Response to Submissions Report

State Significant Development – SSD 18_9095

Armidale High School Redevelopment

Butler Street, Armidale

VIEWS ANALYSIS

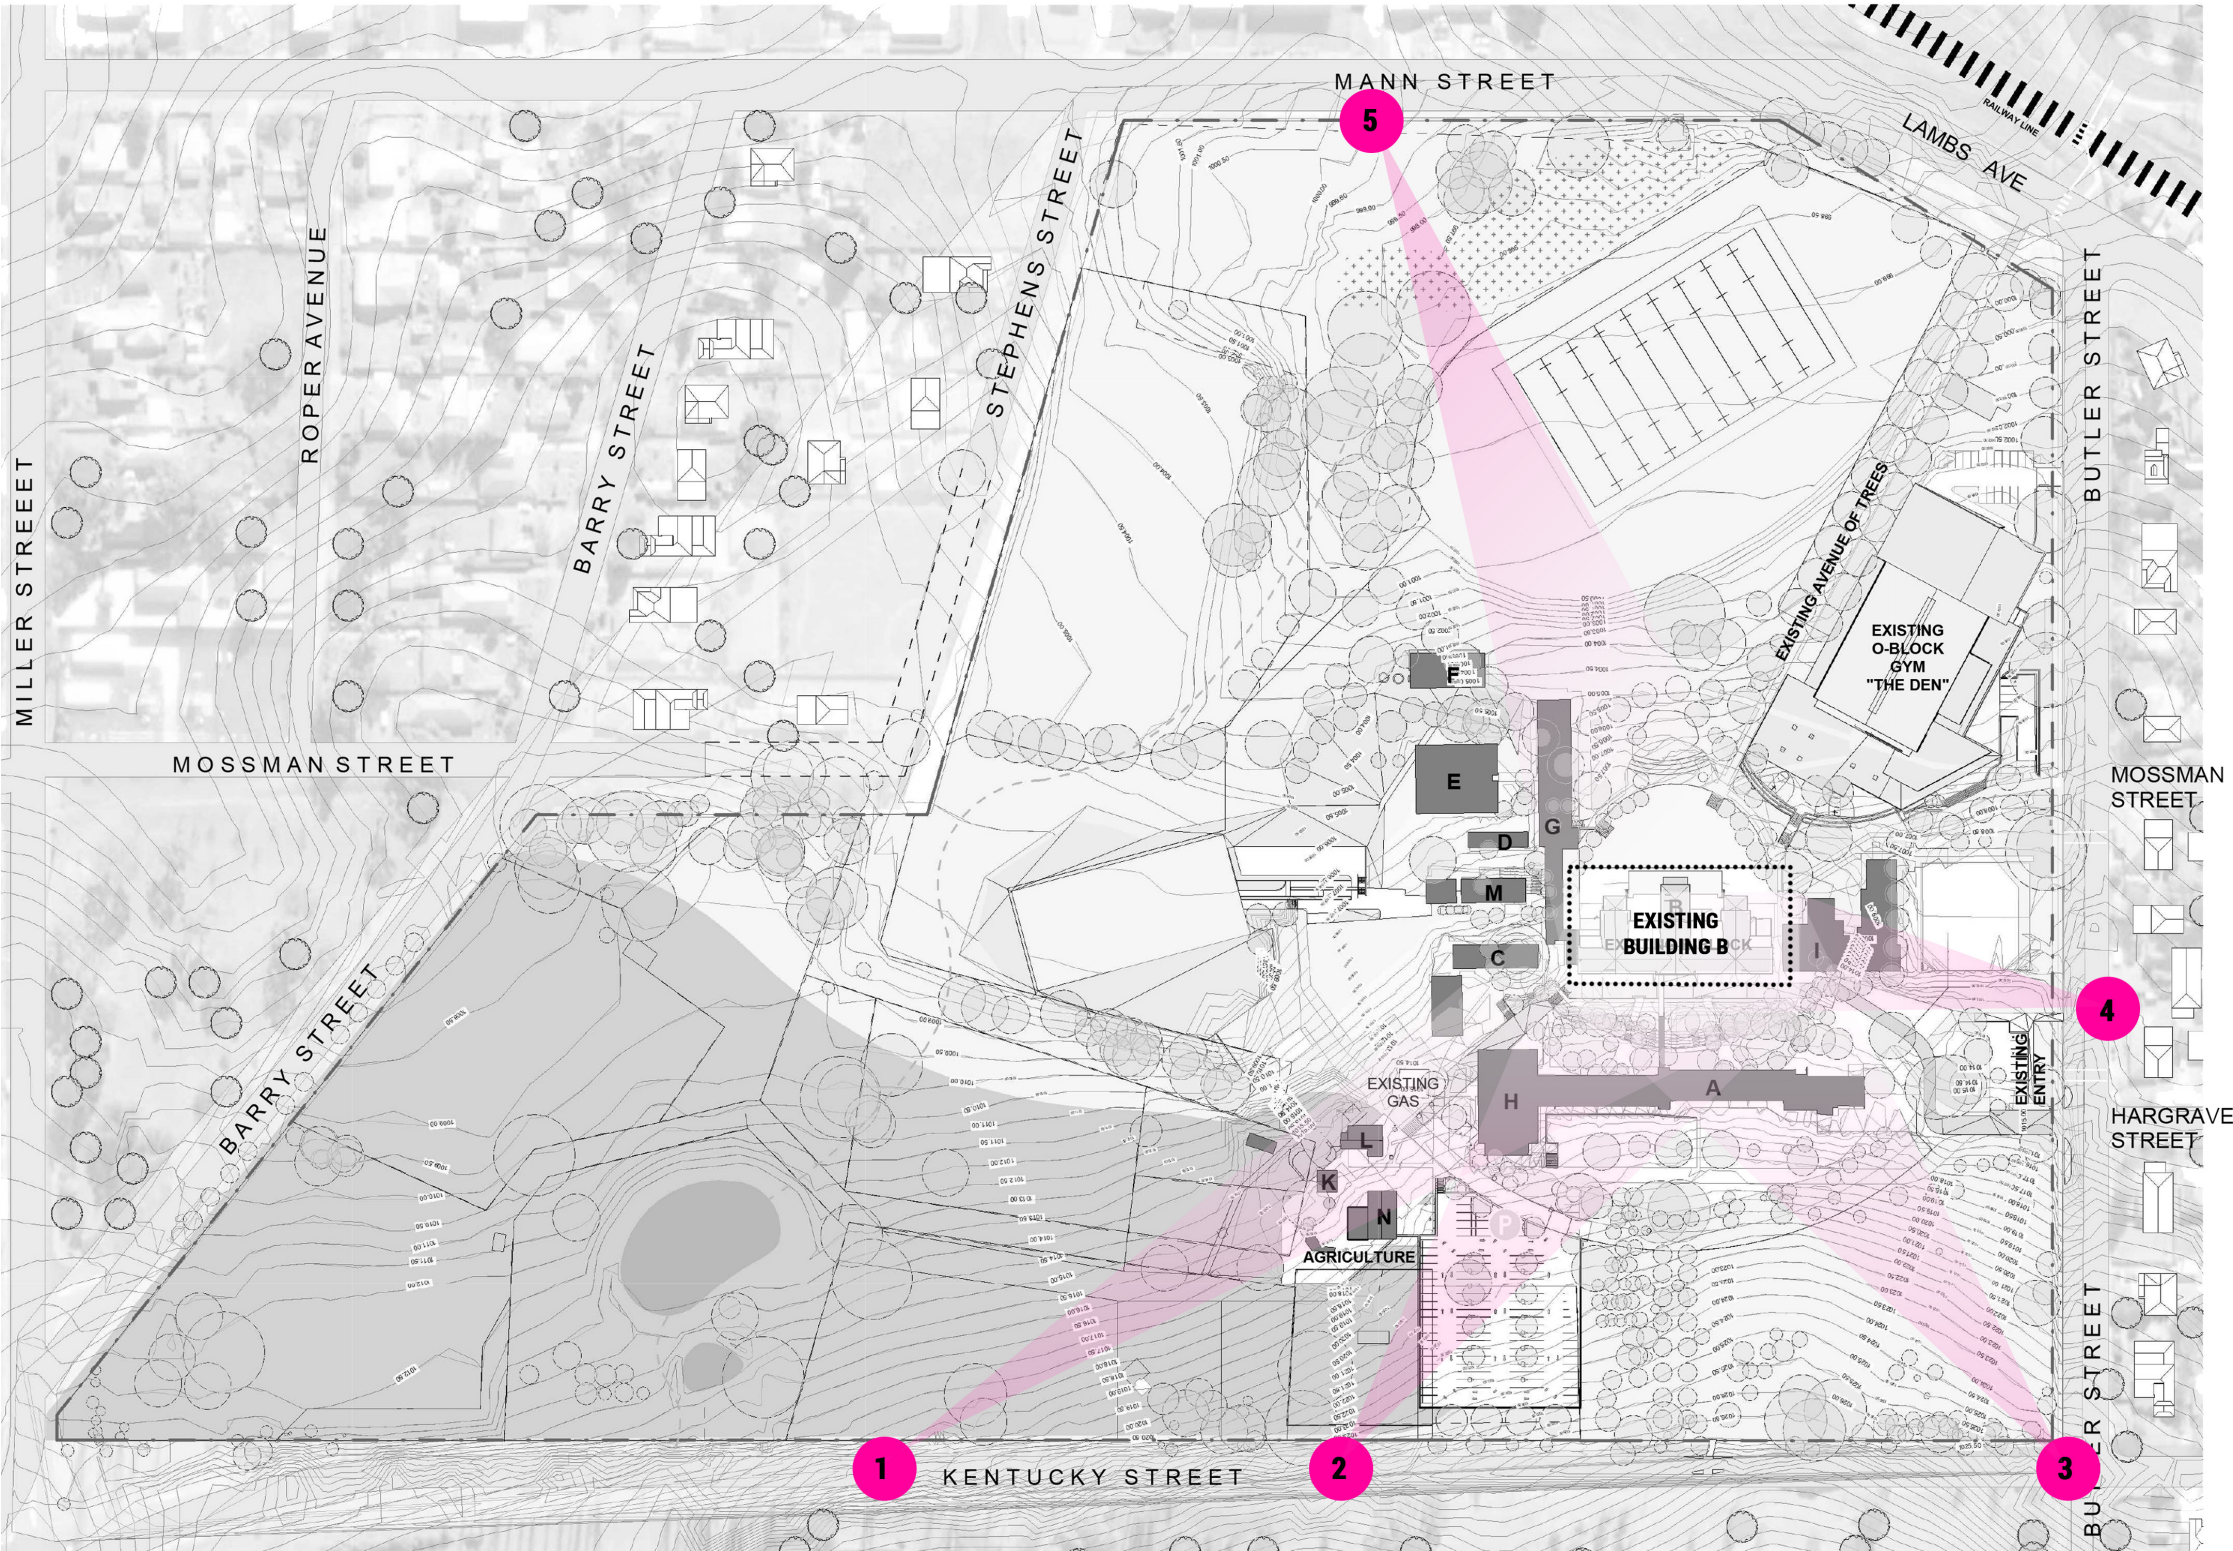
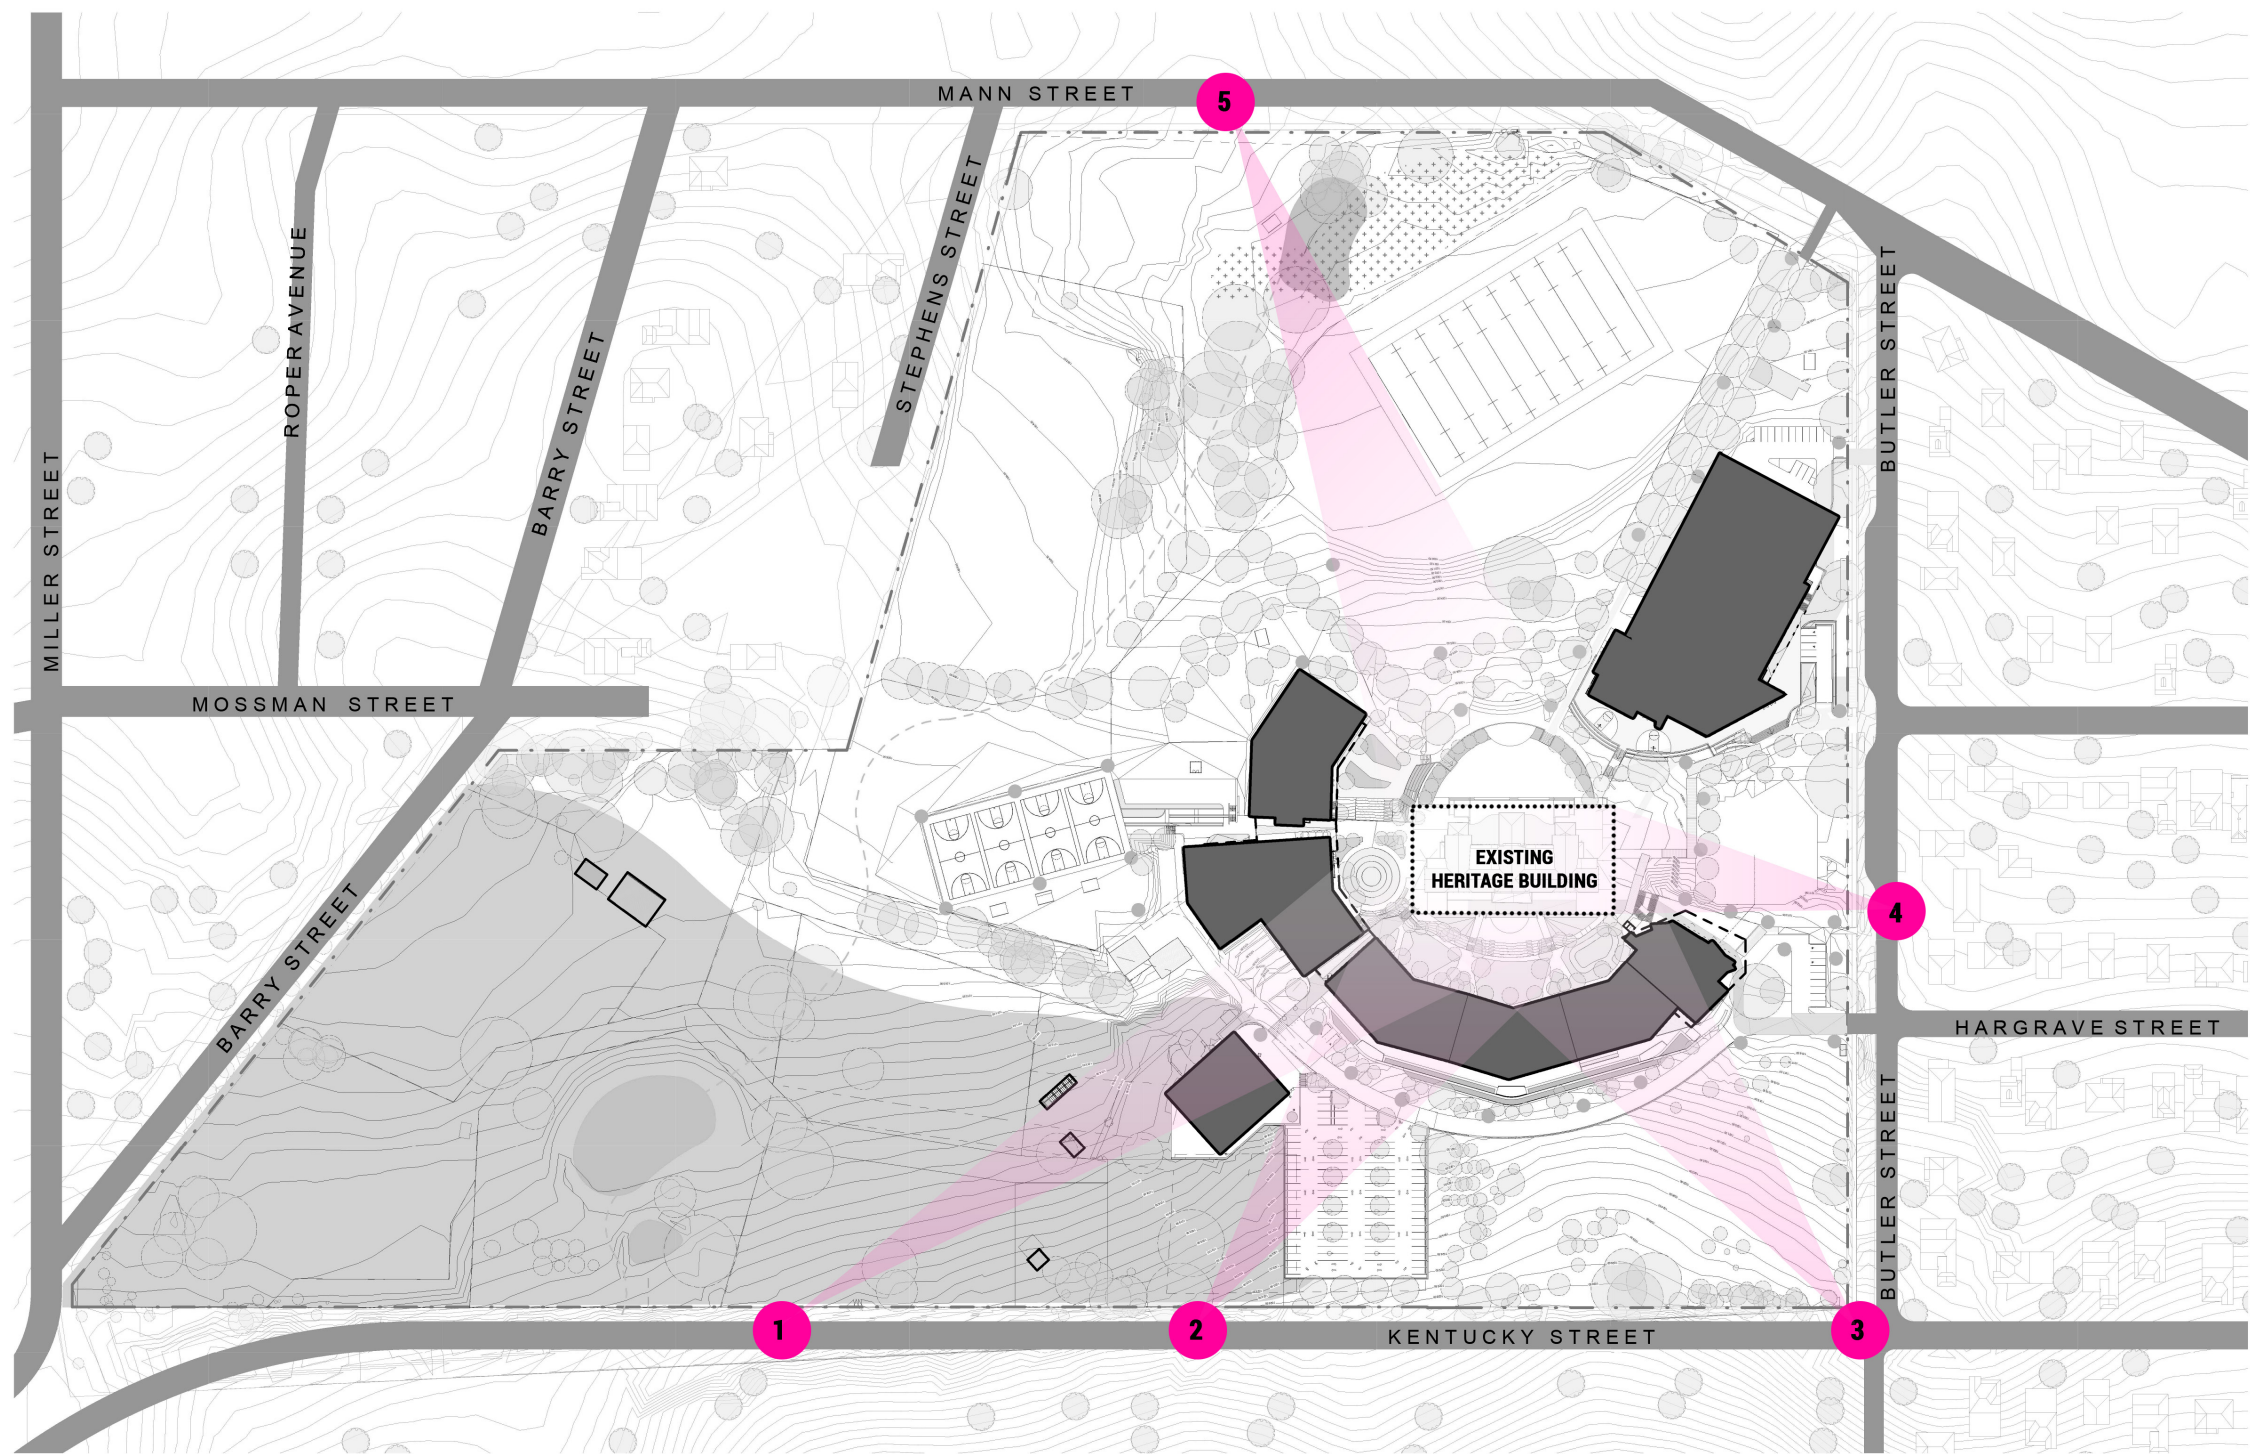
7. While it is acknowledged the Council did not raise concerns with regard to the proposed development, the Heritage Council has raised concern with regard to the impact of the proposal on significant views to the locally listed heritage item. Additional information is required addressing the impact of the proposal on the significant views.	The View Analysis provided as part of the original DA submission (refer Appendix 16 of the EIS) has been updated to provide additional information, including: - Comparison between existing and proposed views at significant viewpoints around the site; - Demonstration as to how these views would be maintained with the construction of the proposed buildings; and - Consideration of the impact the proposed buildings would have on significant views, including potential improvement to views or prominence of visual settings within the site. Further, it is noted that the design change to accommodate air conditioning (resulting in an increase in building height by 300mm) has been incorporated into the expanded View Analysis.	View Analysis Appendix 2
